From: alan.story@hertfordshire.gov.uk
Sent: 02 August 2018 15:57
To: Planning
Subject: Planning application 6/2018/1519/MAJ - Land on the north of Chequersfield

District ref: 6/2018/1519/MAJ
HCC ref: WH/185/2018
HCC received: 21/06/2018
Area manager: Manjinder Sehmi
Case officer: Alan Story

Land on the north of Chequersfield
Welwyn Garden City

Erection of 30 residential units with associated vehicular access, associated ancillary and enabling works.

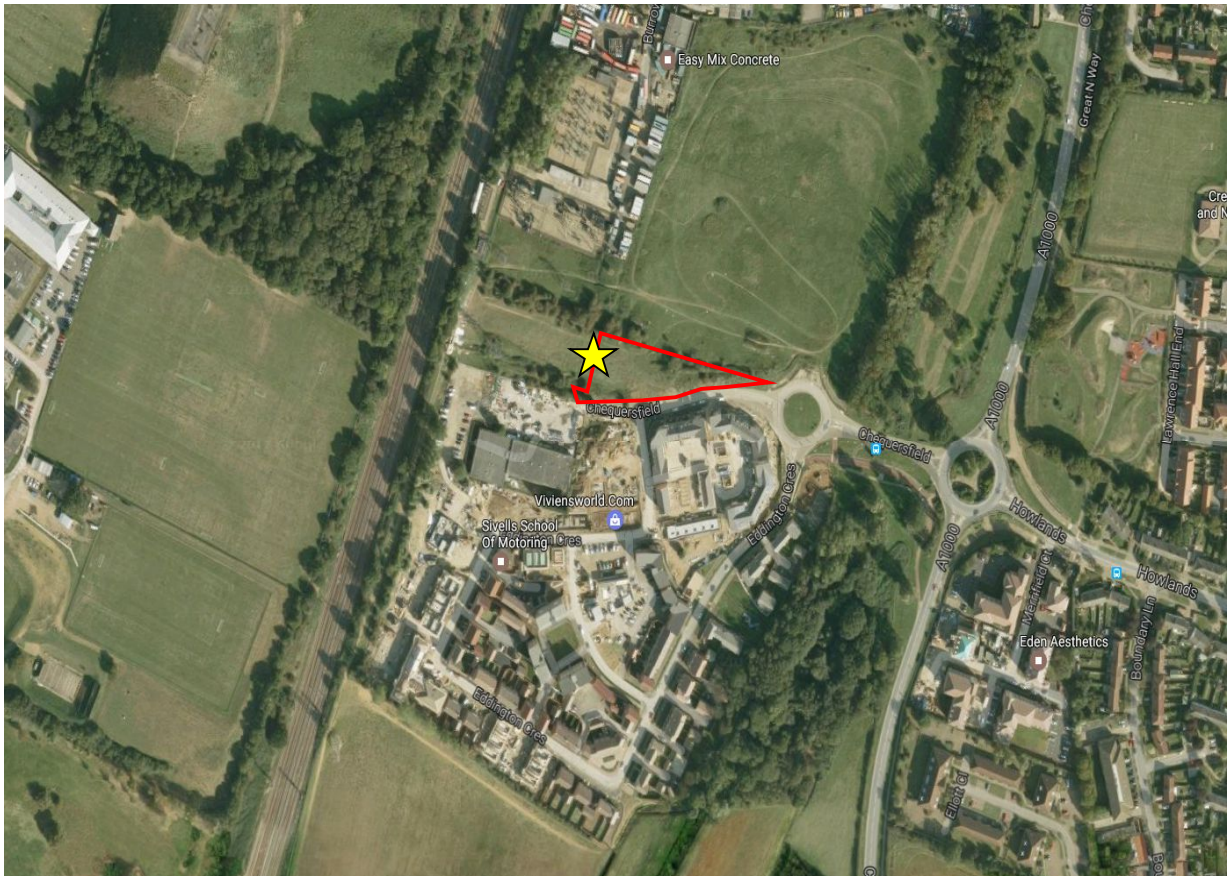
No swept path is shown for the access for emergency / refuse vehicles are able to manoeuvre in a fashion that they may enter / leave in both directions. Swept path is provided for private vehicles only (Transport Statement appendix F – drawing 22573_08_020_01.1) however the Highway Authority would observe that the access road and tactile provision shown is not consistent with Drwg LSD209-01 F, The swept path drawing shows footways to a different alignment, with provision from within the site to the footway along the northern side of Chequersfield. Tactile crossing facilities are shown, however not necessarily at a desire line, and involves crossing at a particularly wide section. Carriageway width (back from bellmouth) is shown as 5.5m max on the swept path plans, contrary to the width as scaled from LSD209-01 F)

Drawing 22573_08_020_01.1 rev A (appendix F to the TS) provides details that visibility from the access shall be provided to MfS standards appropriate for speeds in this location. HCC observe, as above, that drawing 22573_08_020_01.1 rev A does not appear to match scheme proposals as shown on drawing LSD209-01 F, consequently the extent that parking spaces interfere with visibility to the east is unclear. Actual development proposals place parking closer to the kerb radii of the junction, thereby impacting greater on visibility than that shown in the TS.

Rev F: Footpaths to bin stores all increased to min 2m width as requested by WHBC.  
UNIT 1 PRESTON LODGE COURT | PRESTON DEANERY | NORTHAMPTON | NN7 2DS | T: 01604 871199 | W: www.lsdev.co.uk | E: info@lsdev.co.uk

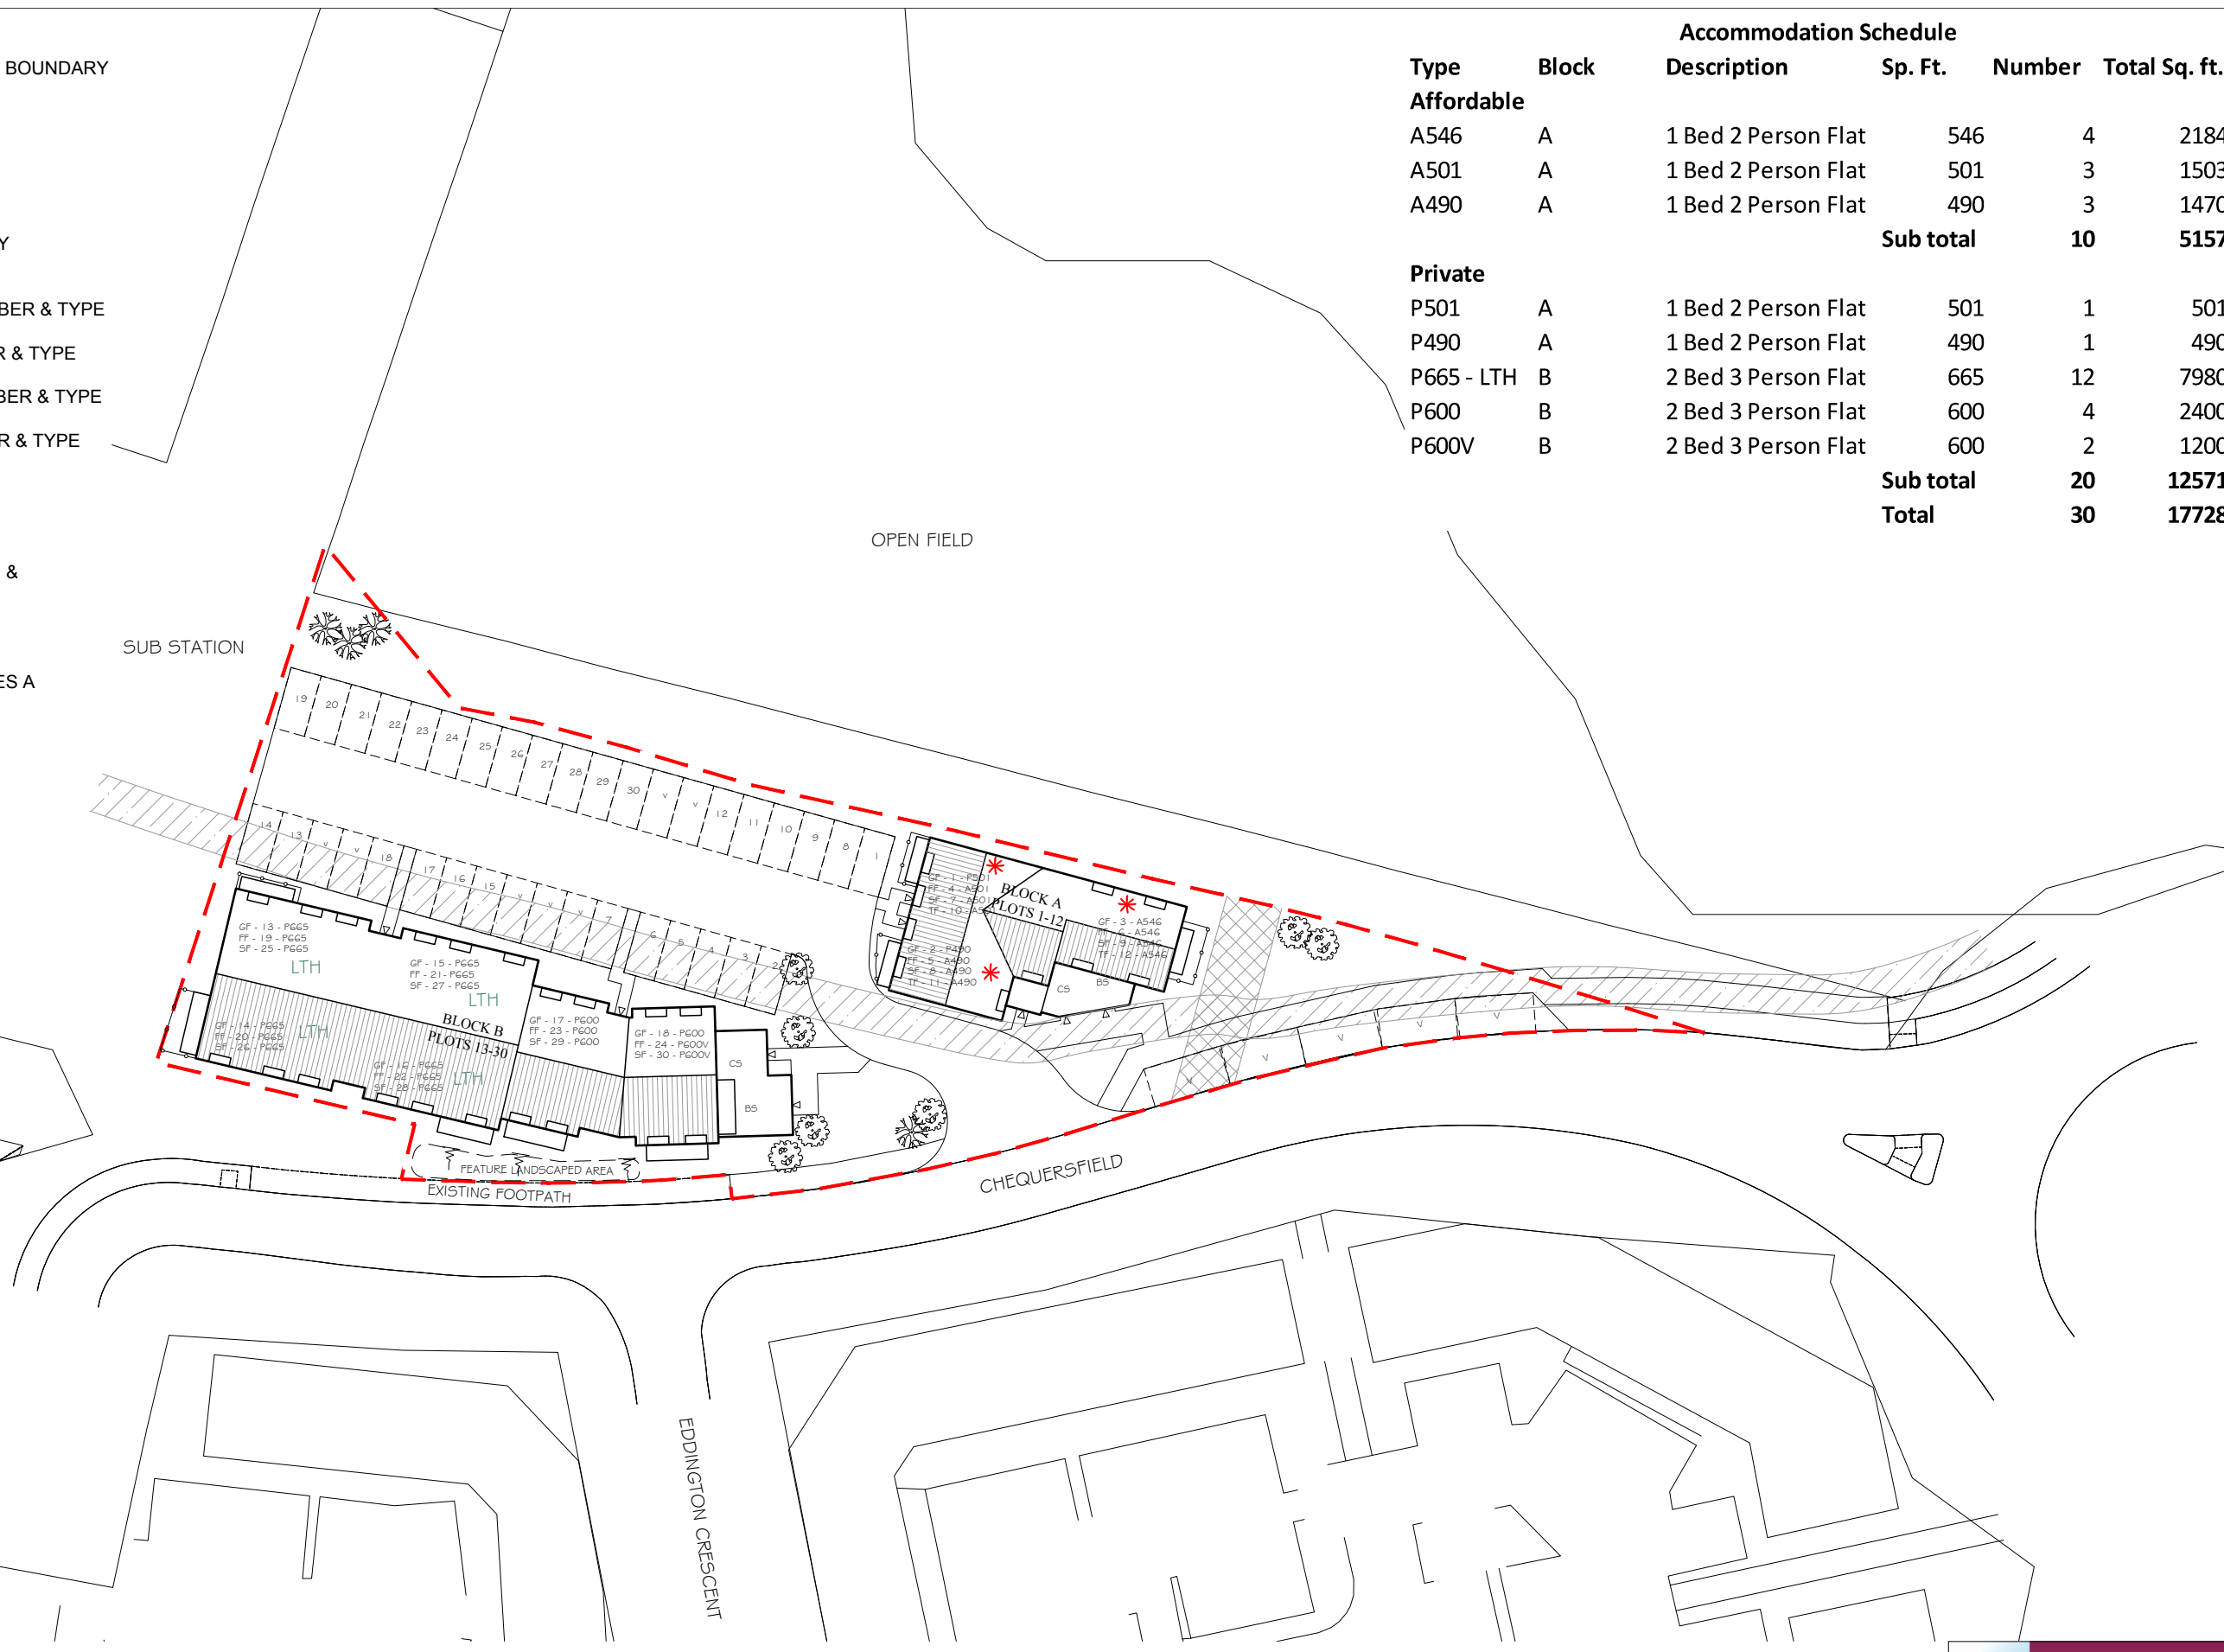
The access is shown provided to 17.8m at the junction, reducing to 12.7 at back edge of footway. Such a width is unacceptable – representing an unacceptably wide vehicle access, and an increased point of conflict between pedestrians and vehicles. Roads in Hertfordshire would require a Minor or Major Access to serve a development of this scale, representing carriageway width of 4.8m or 5.5m with footways.

Notwithstanding the above position, the parking arrangement as proposed is not workable. Bays are drawn to a maximum length of 4.8m and 3m deep. The additional width shall partially remove parking from within visibility splays from the new access, and would enable the operation of car doors without detriment to Chequersfield, but the allocated length of bay is insufficient to accommodate 5 vehicles. Manual for Streets identifies parking bays parallel to the highway should be 6m in length in order to enable vehicles to access / leave such spaces without undue detriment.

The proposed inset parking bays are provided almost abutting the necessary kerb radii, and in fact – the tails on approach to the western end bay require the removal of radii kerbs. The parking of vehicles so close to the access shall result in unnecessary confusion between vehicles trying to park and those exiting the development, as well as confusion to drivers along Chequersfield as to whether drivers in front are intending to enter the development or park in the bays.
